# CITY OF ALBUQUERQUE

October 11, 2022

Re: **New Mexico Expansion**  
**4401 Alexander Blvd. NE**  
**Traffic Circulation Layout**  
Engineer's/Architect's Stamp XX-XX-XX (F16-D003B1)

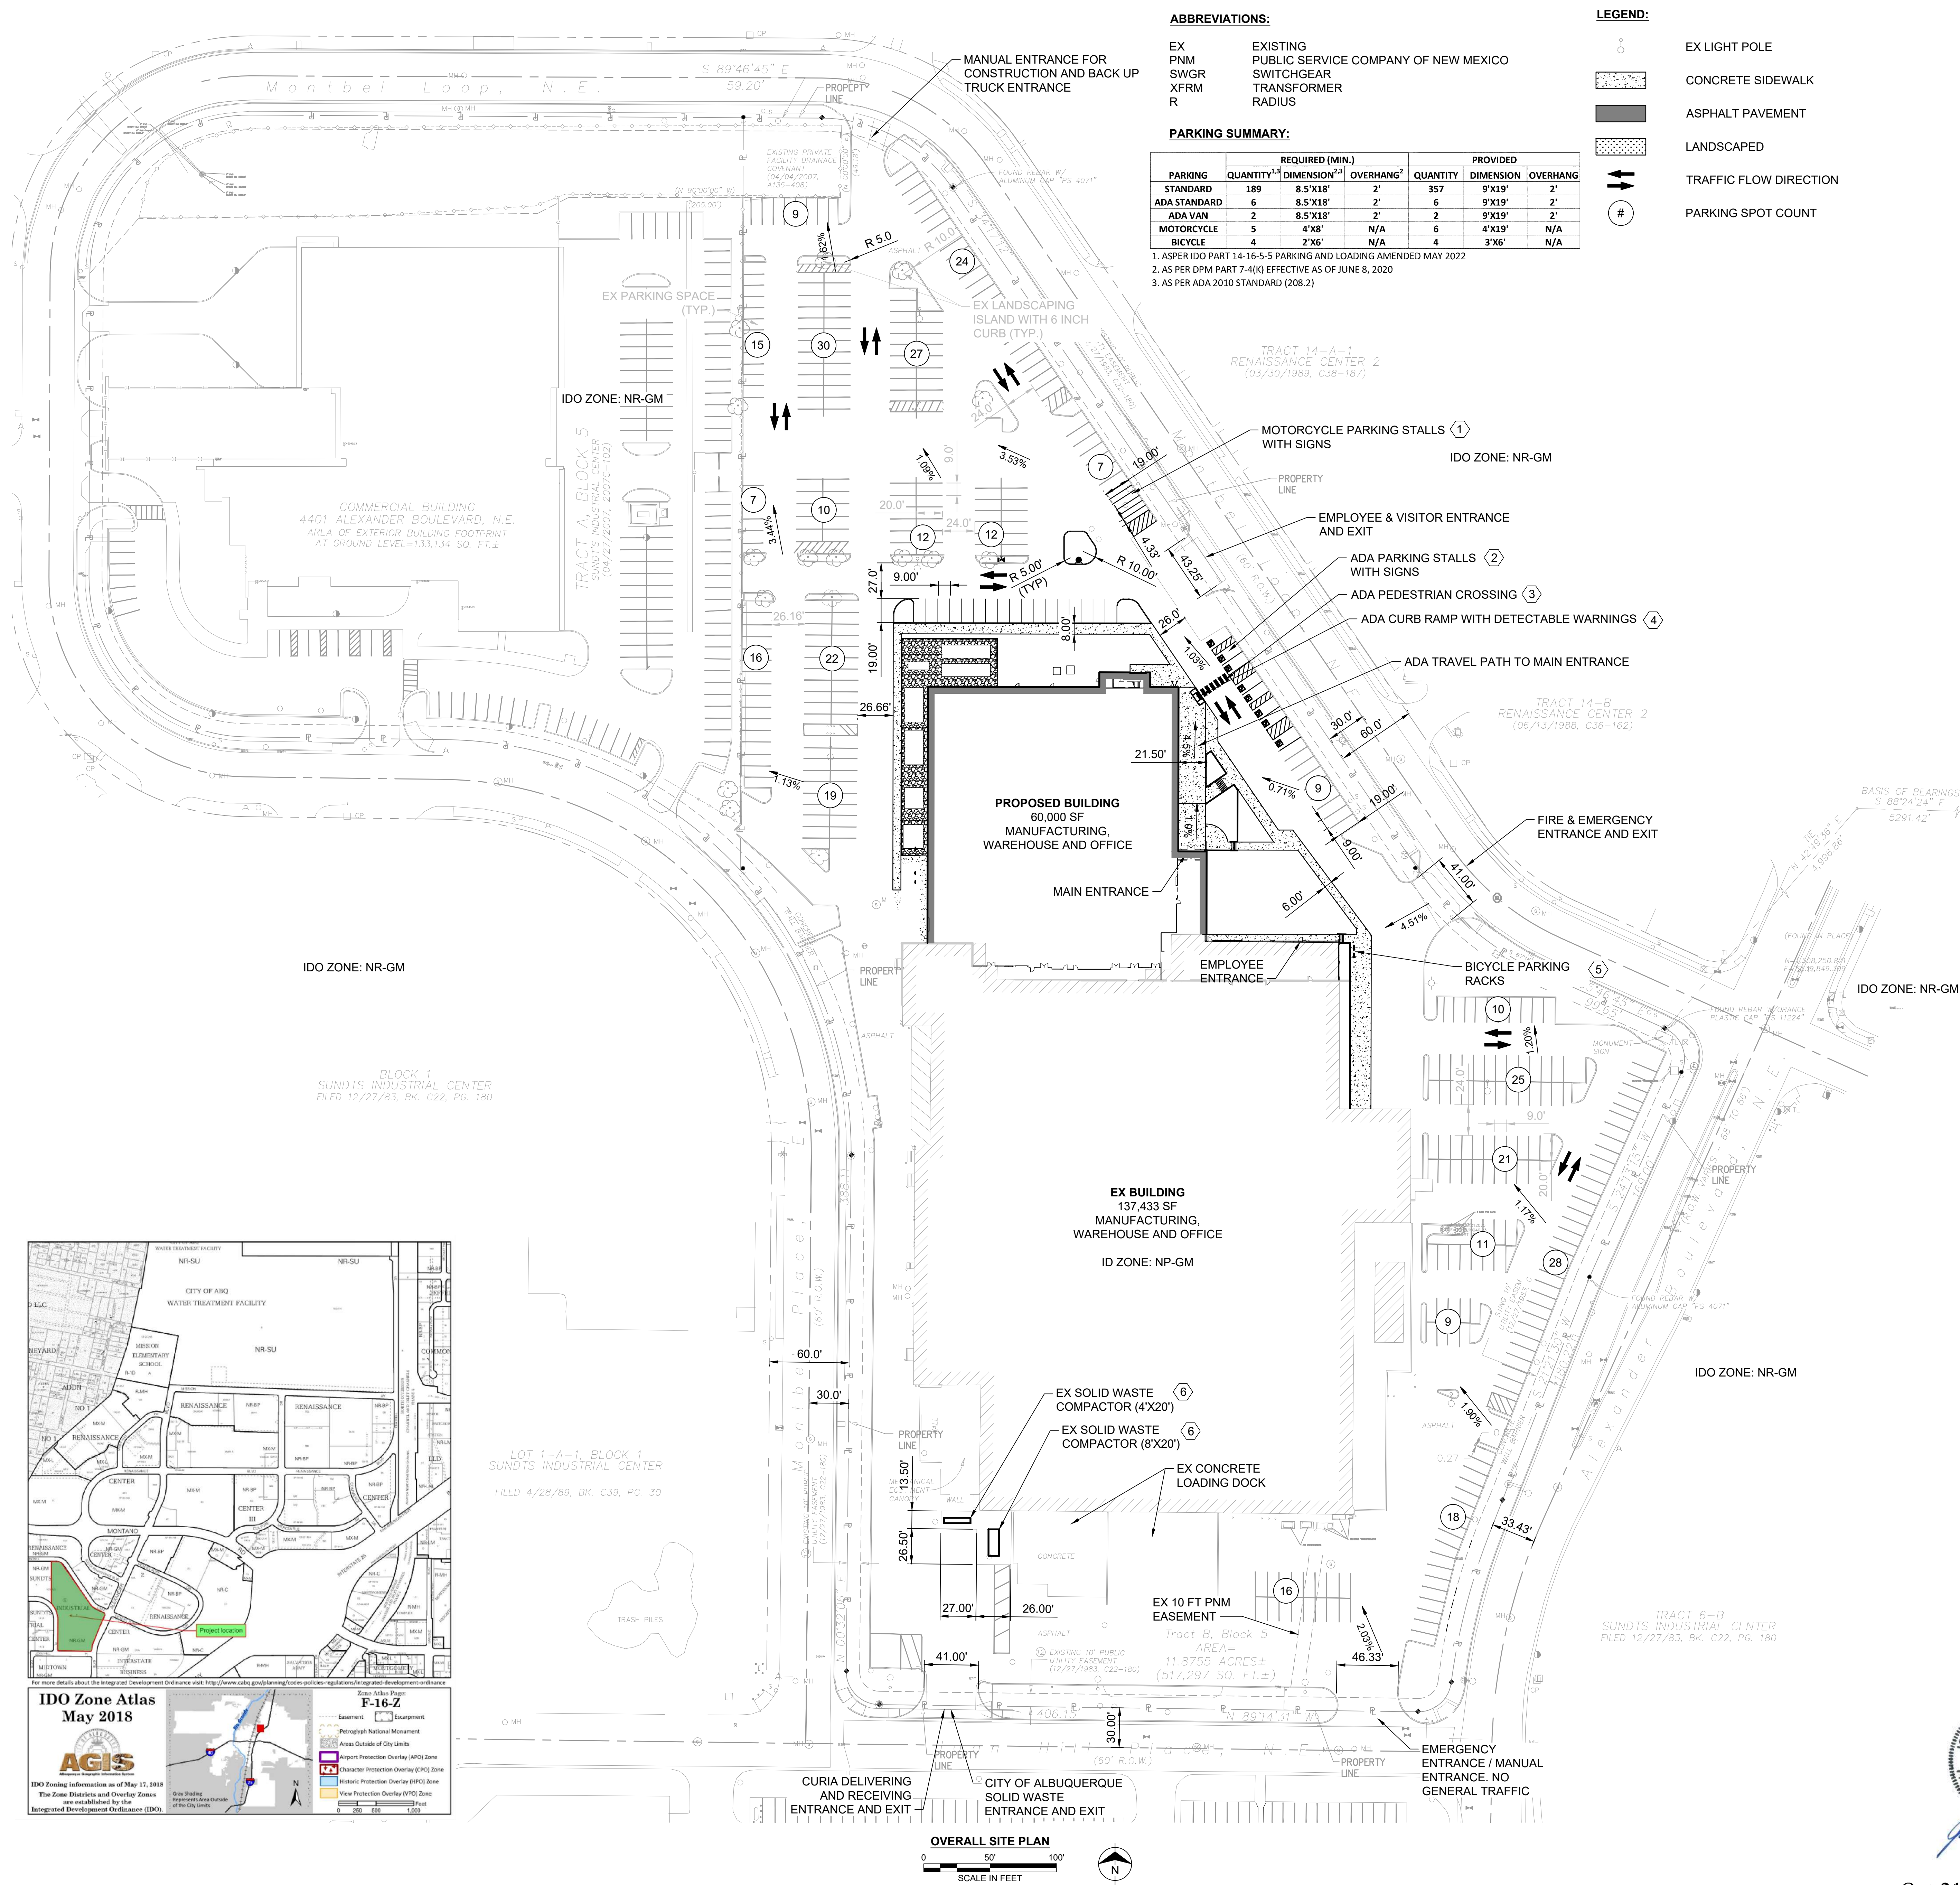
1. List the number of Motorcycle and Bicycle parking spaces required by the IDO.
2. The traffic circulation layout must be stamped, signed, and dated by an engineer or architect licensed in the state of New Mexico.
3. Clarify existing property lines and proposed property lines.
4. Sidewalk need to be built at the perimeter of the site, and reference COA std dwg 2430.
5. All sidewalks along streets should be placed at the property line.
6. Due to proposing gates, please provide turning templates.
7. Please list the width and length for all existing and proposed parking spaces. Some dimensions are not shown.
8. The minimum parking stall dimensions are:

12. The pavement marking "MC" should be shown in the opposite direction for motorcycles entering the parking space.
13. All bicycle racks shall be designed according to the following guidelines:

17. Please provide details for all the proposed signs and pavement marking.
18. Per the IDO, a 6 ft. wide ADA accessible pedestrian pathway is required from the public sidewalk to the building entrances. Please clearly show this pathway and provide details.

21. Define ADA pathways by labeling of ramps, flush pavement, dimensioning of pathways, doorways, etc.
22. Curbing should be installed to delineate landscape, parking, and pedestrian ways and identify points of access. Please call out detail and location of barrier curb.

25. It is not apparent what type of pavement surface is being proposed. A hard driving surface will be required as part of this proposed project for parking area and drive aisles.

26. Please provide a sight distance exhibit
27. Show the clear sight triangle and add the following note to the plan: "Landscaping and signage will not interfere with clear sight requirements. Therefore, signs, walls, trees,

PARALLEL CURB RAMP

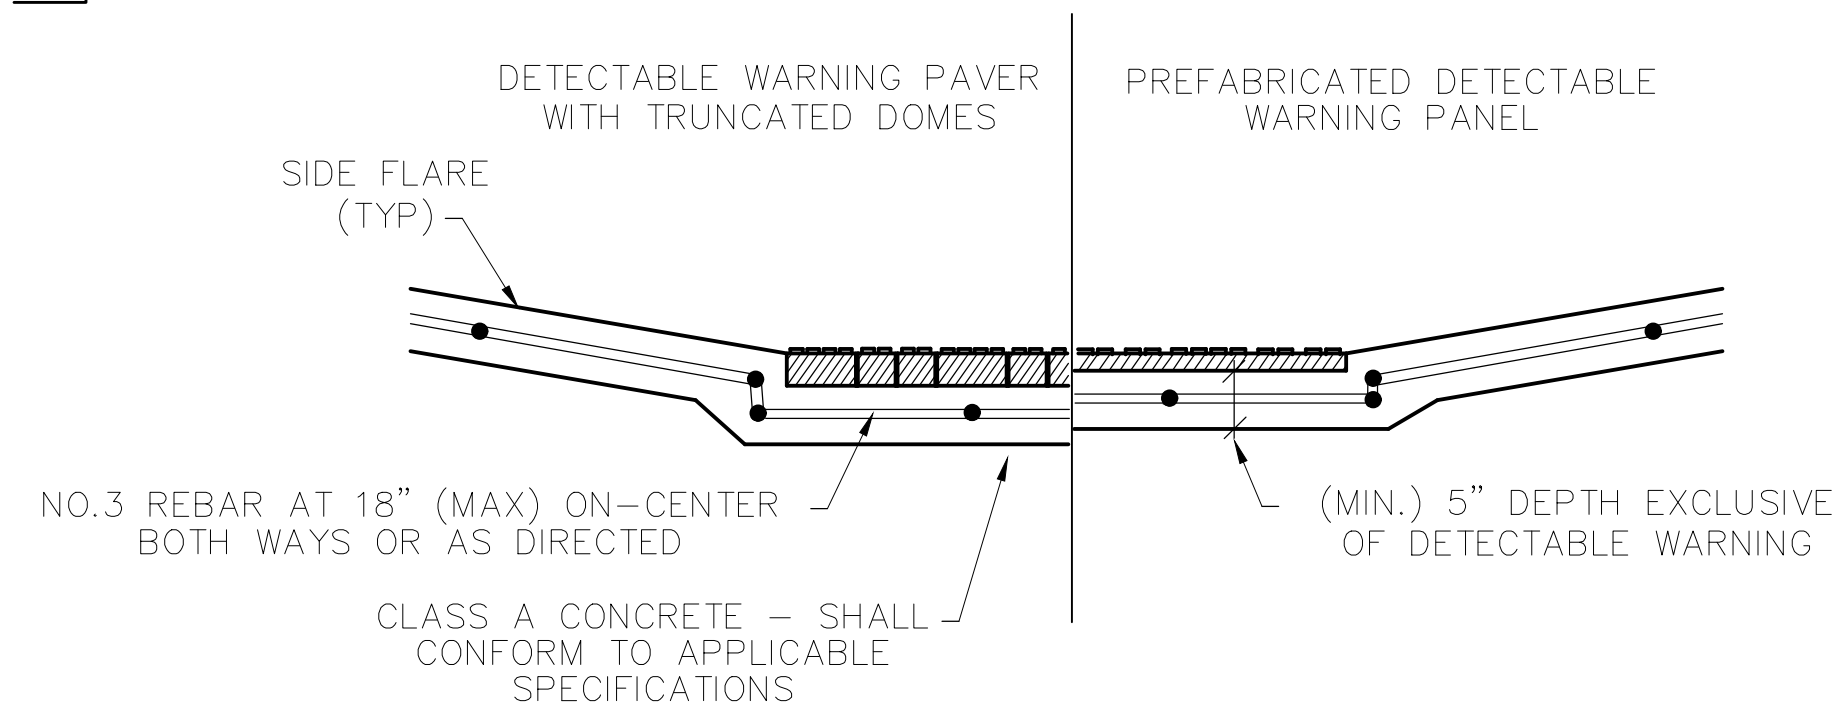
9. The ADA accessible parking sign must have the required language per 66-7-352.4C NMSA 1978 **"Violators Are Subject to a Fine and/or Towing."** Please call out detail and location of signs.
10. ADA curb ramps must be updated to current standards and have truncated domes installed.
11. Motorcycle parking spaces shall be designated by its own conspicuously posted upright sign, either free-standing or wall mounted per the zoning code.

BICYCLE PARKING STALL  
DETAIL  
NOT TO SCALE  
1  
CS100

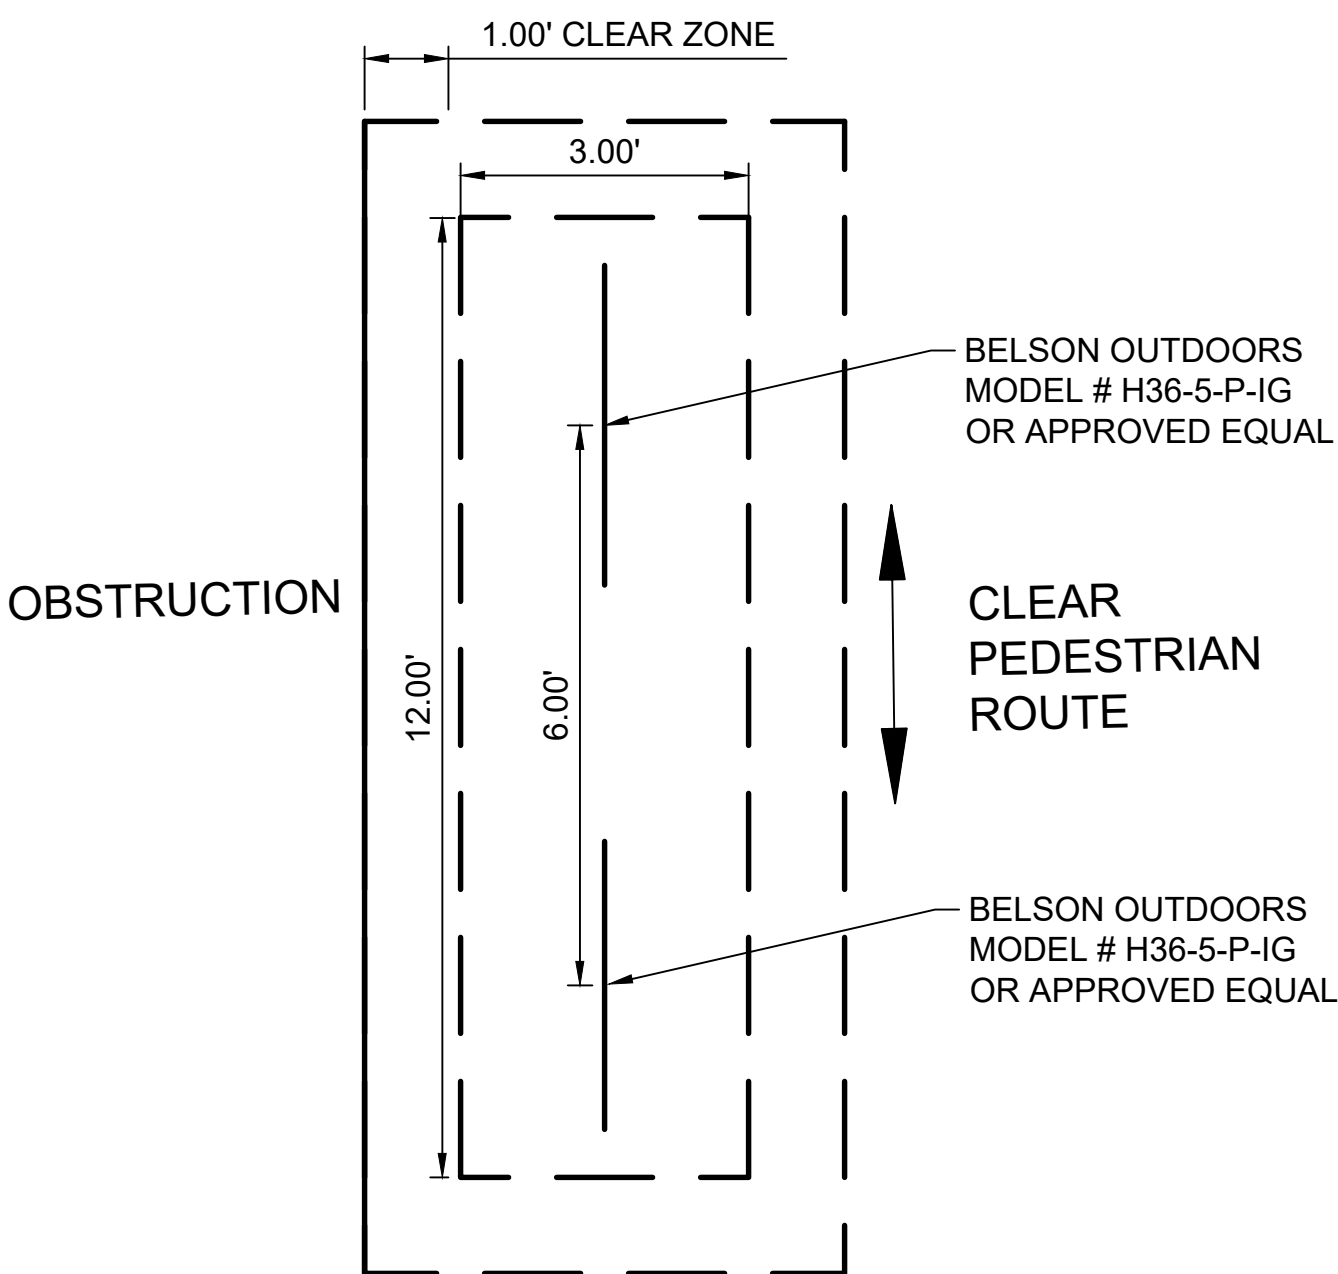
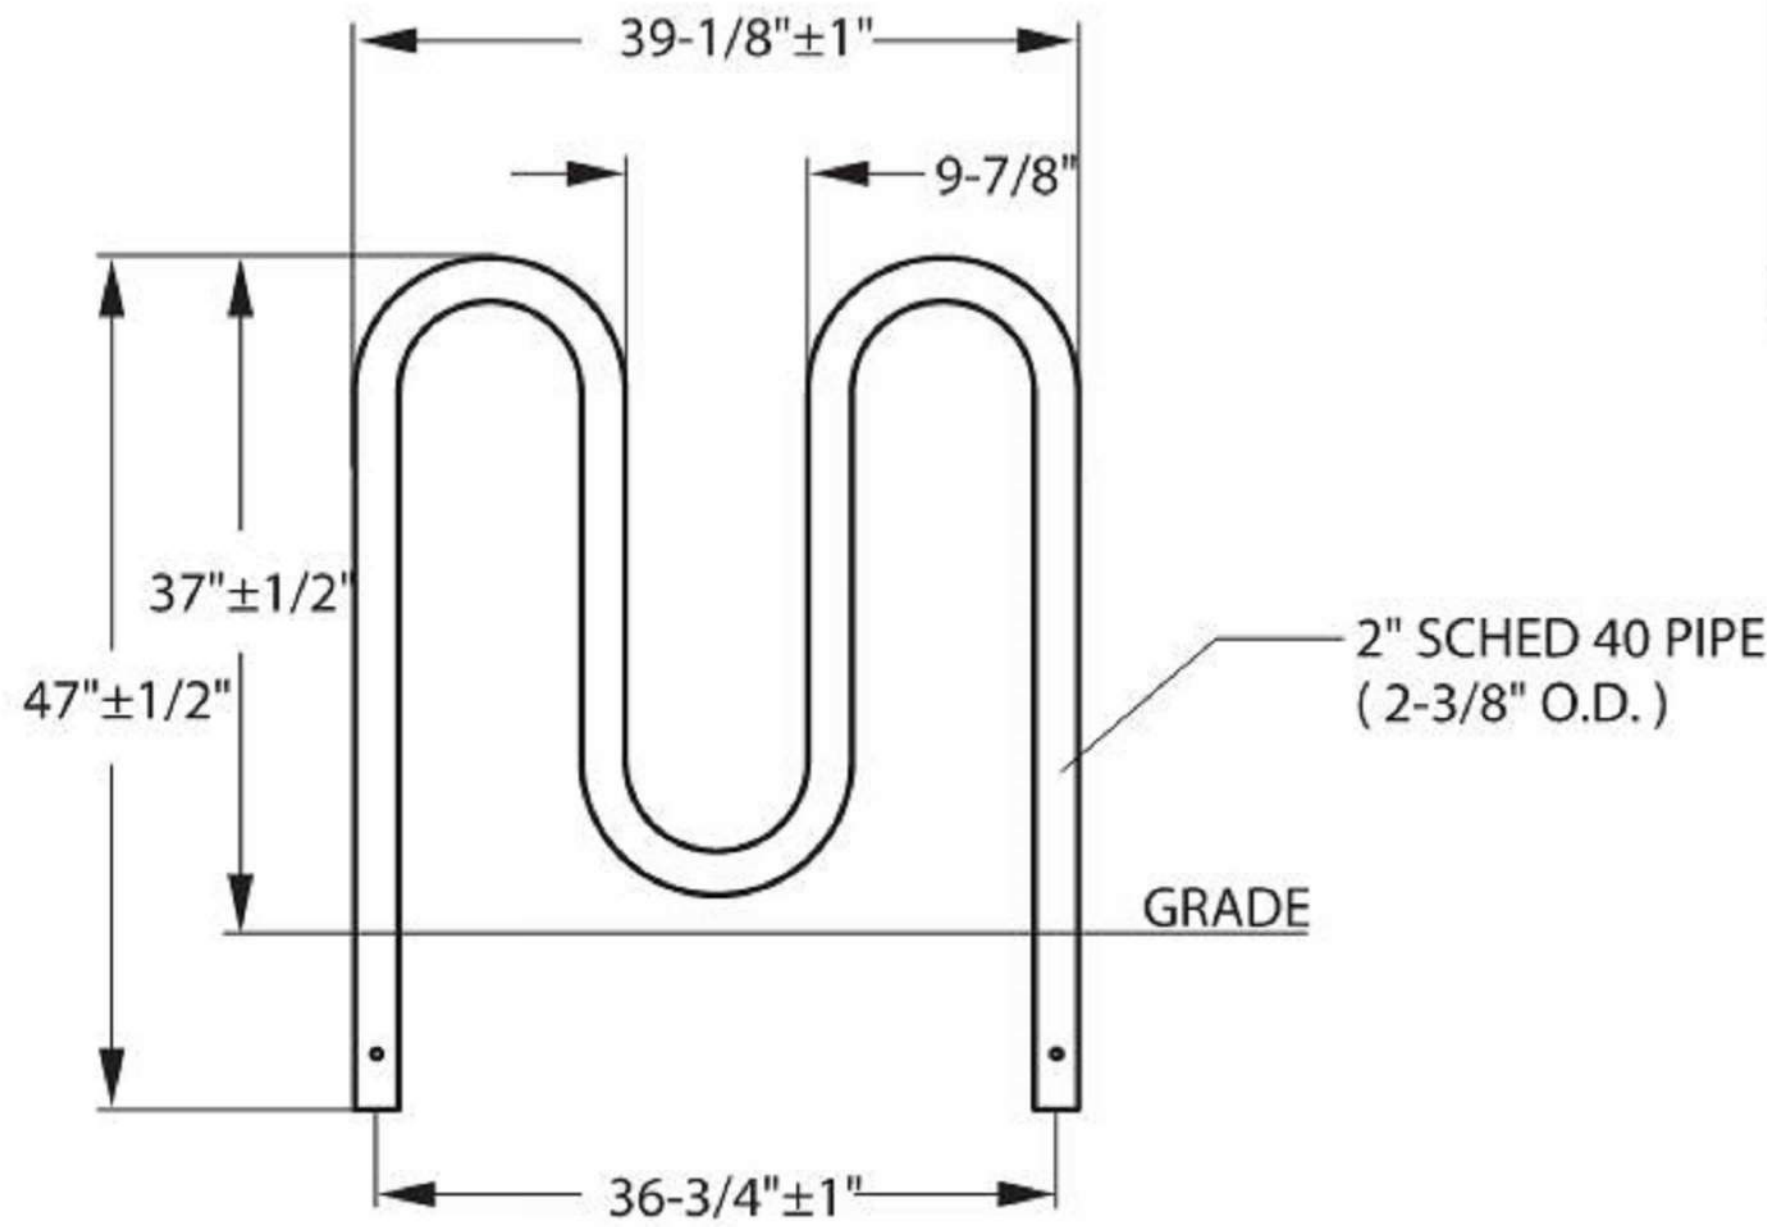
- a. The rack shall be a minimum 30 inches tall and 18 inches wide.
  - b. The bicycle frame shall be supported horizontally at two or more places. Comb/toaster racks are not allowed.

- c. The rack shall be designed to support the bicycle in an upright position. See the IDO for additional information.
  - d. The rack allows varying bicycle frame sizes and styles to be attached.

- e. The user is not required to lift the bicycle onto the bicycle rack.
  - f. Each bicycle parking space is accessible without moving another bicycle.

14. Bicycle racks shall be sturdy and anchored to a concrete pad.
15. A 1-foot clear zone around the bicycle parking stall shall be provided.
16. Bicycle parking spaces shall be at least 6 feet long and 2 feet wide.
